## OFFICIAL NOTICE OF DECISION

CITY OF ALBUQUERQUE  
PLANNING DEPARTMENT  
DEVELOPMENT REVIEW BOARD

1. **Project # 1001816**  
06DRB-01794 Major-Vacation of Public Easements

JANE CARLTON request(s) the above action(s) for all or a portion of Lot(s) 12-A, **NEW MEXICO TOWN CO. ORIGINAL TOWNSITE**, zoned SU-2/HDA, located on TIJERAS AVE NW, between LOMAS NW and CENTRAL NW containing approximately 1 acre(s). (J-13)

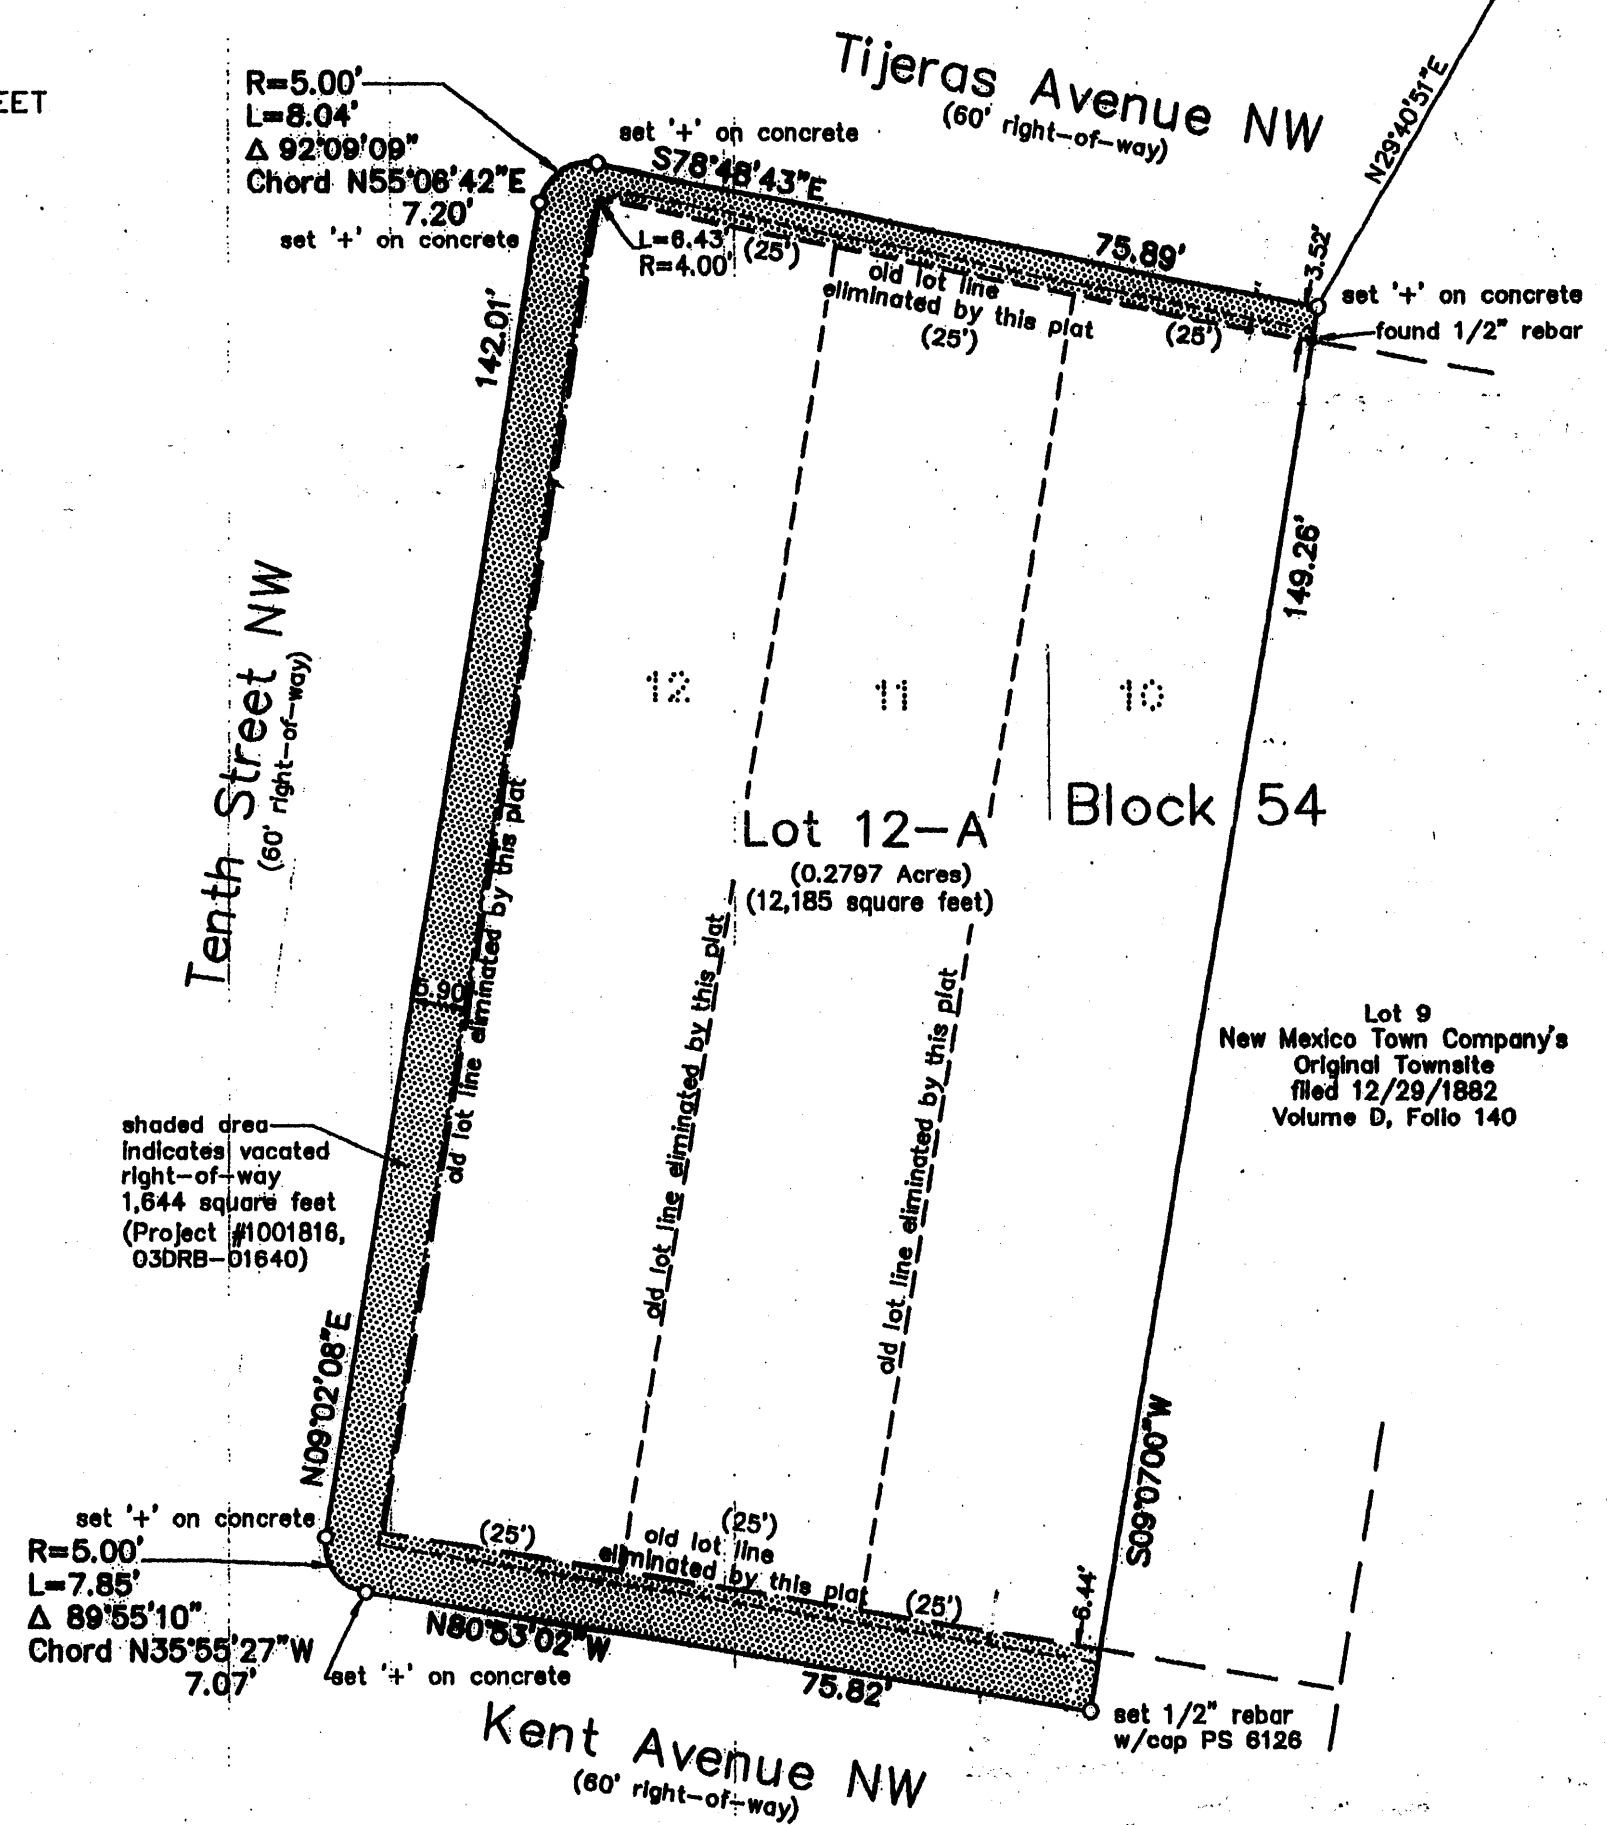
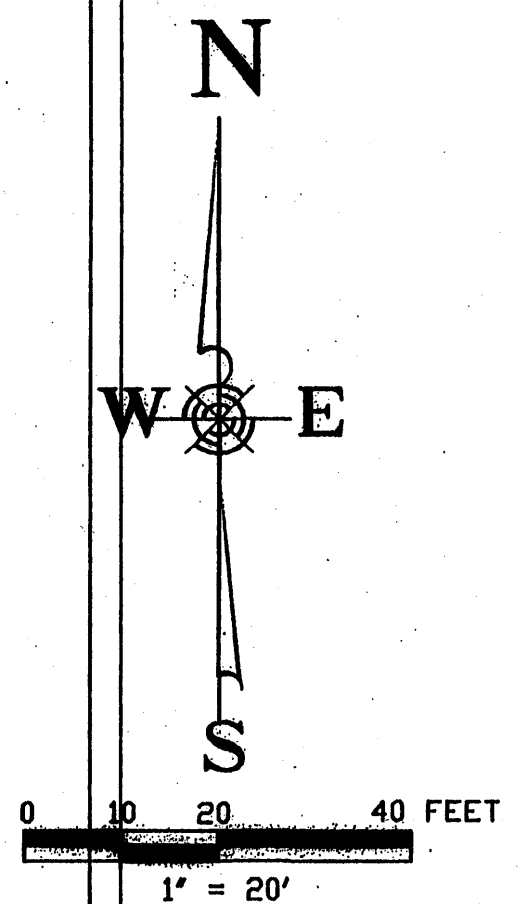
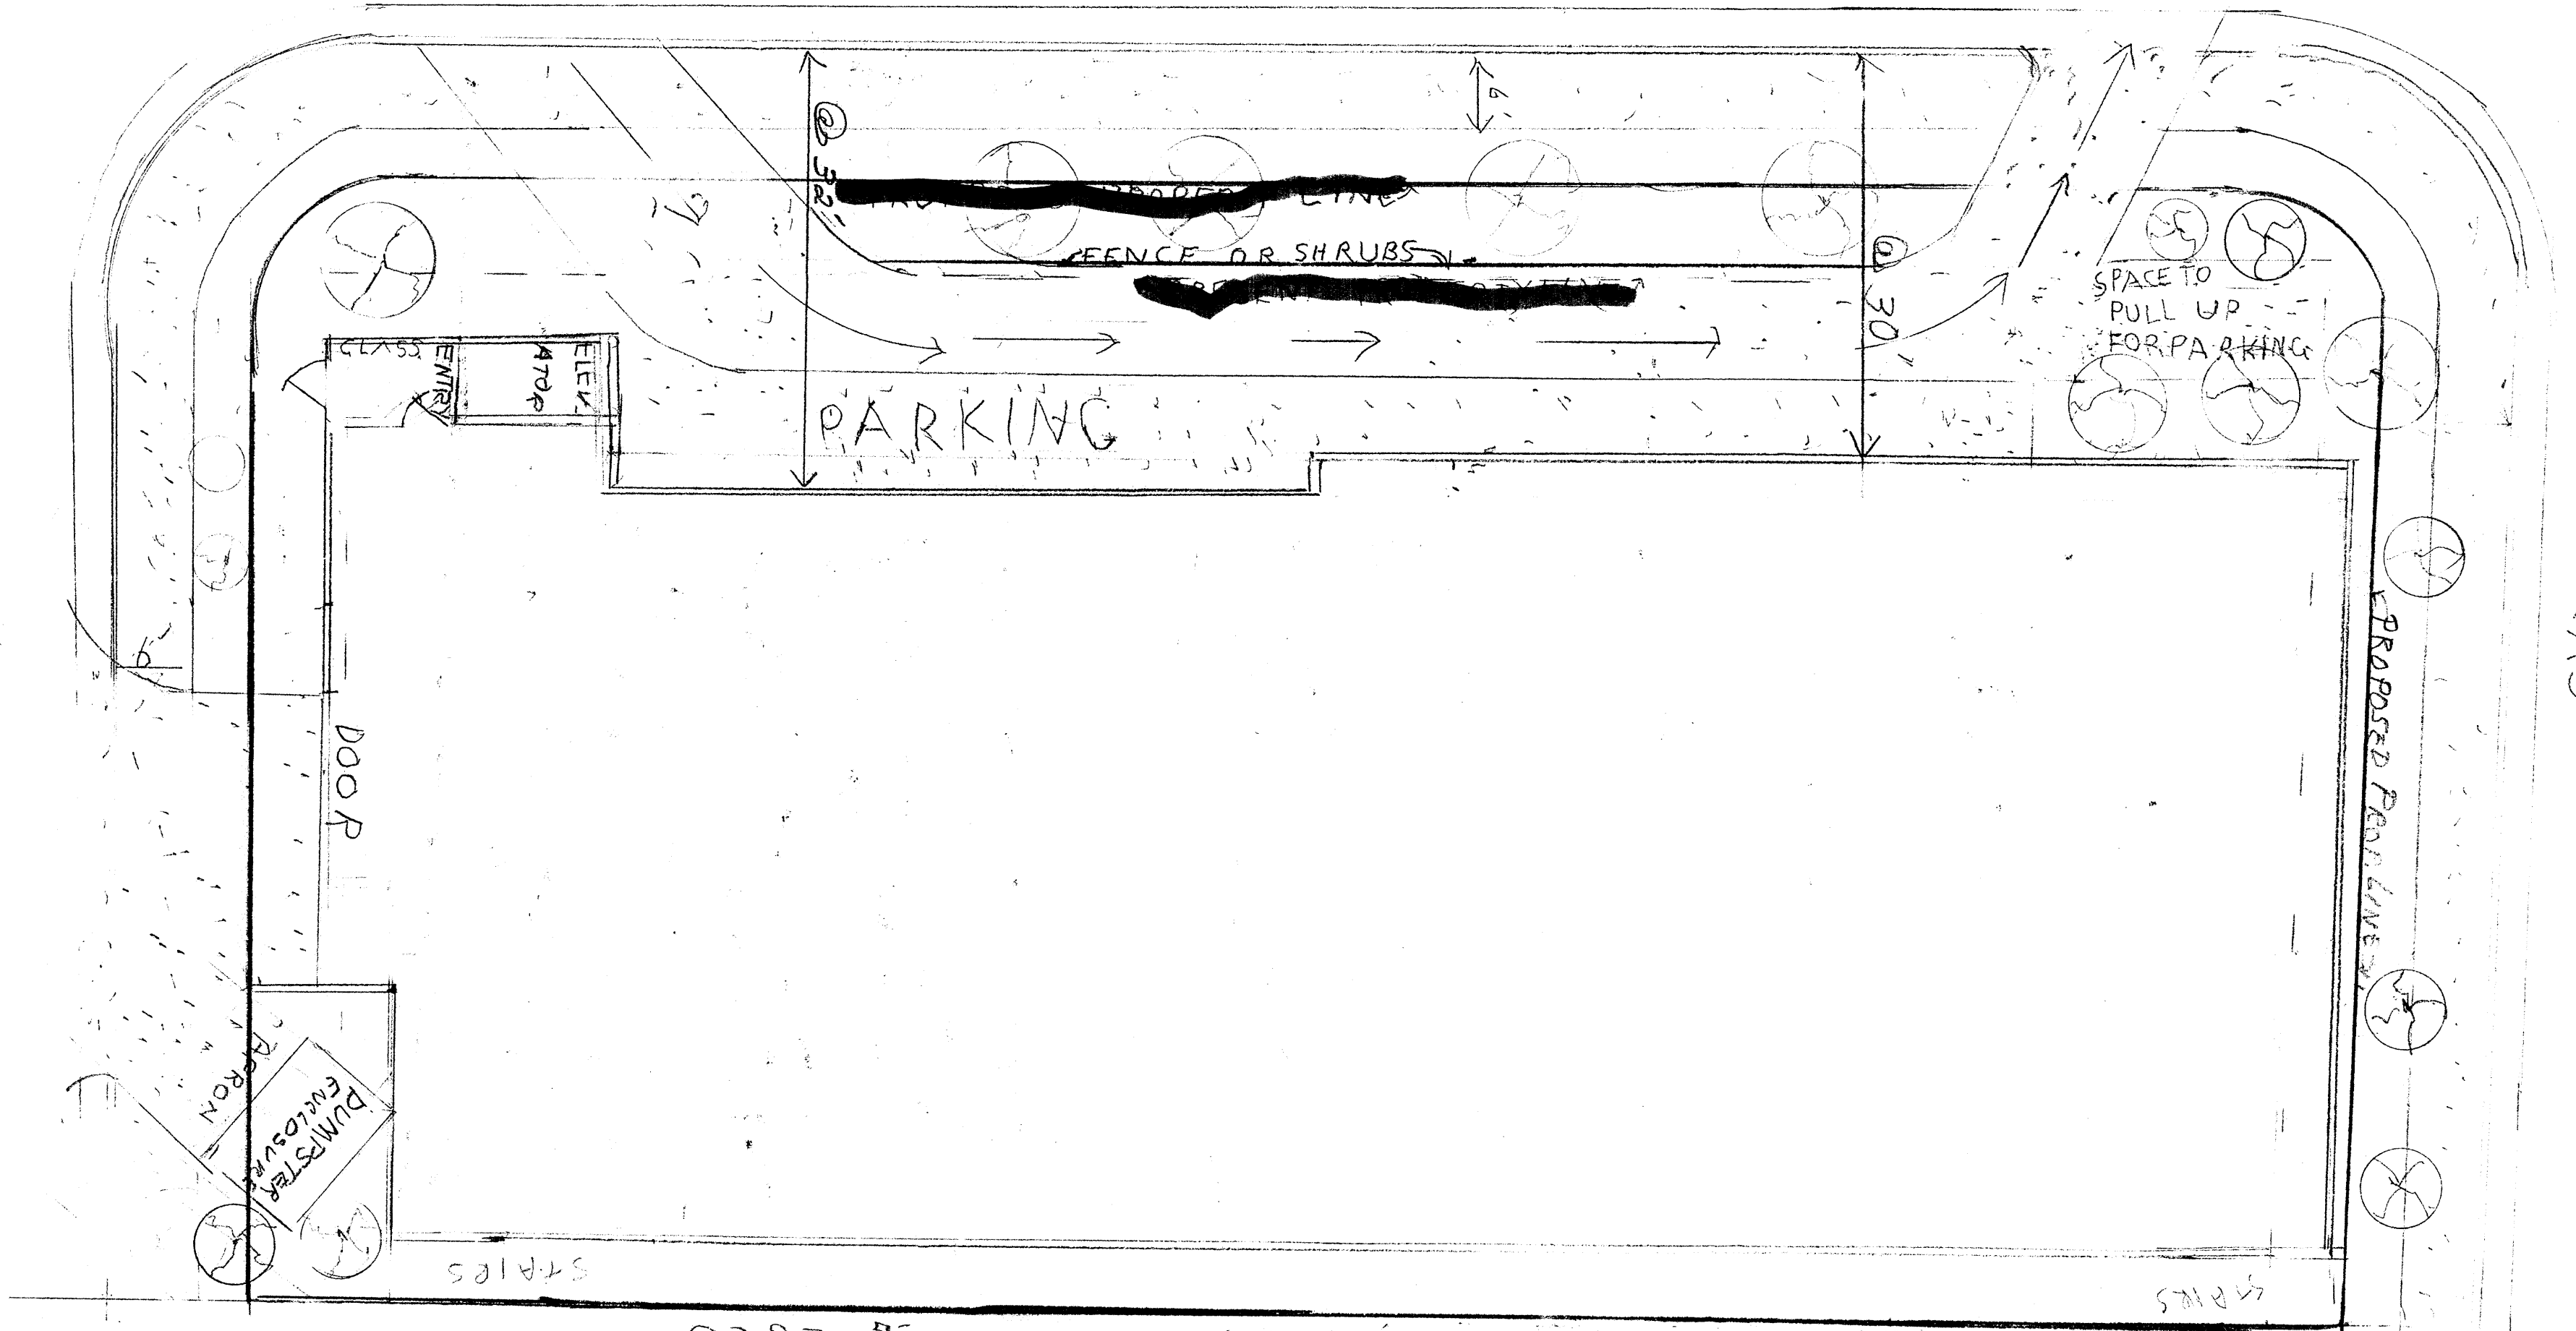
COG Tijeras Ave is designated a minor arterial on the Long Range Roadway System Map with an established right of way of 86 feet. Coordination with DMD is recommended to insure project conformity with this established policy of the MTB.

Transit Whether moved or not, sidewalks should be maintained or constructed to provide for pedestrian accessibility.

Where is the vacation exhibit? Will the replat require the sidewalks to be moved? What will be the distance from the face of curb to the new property line? The new sidewalks will have to be on an infrastructure list and the location will need to meet DPM requirements.

There must be a sidewalk on all sides of this property that front a street. Defer to Transportation Development. If approved, applicant has one year to file the plat completing the vacation action.

At the January 17, 2007, Development Review Board meeting, the vacation was approved as shown on Exhibit B in the Planning file, subject to these findings and conditions:

1. The vacated property shall be shown on a replat approved by the Development Review Board and the approved replat shall be filed for record with the Bernalillo County Clerk's Office within one year.
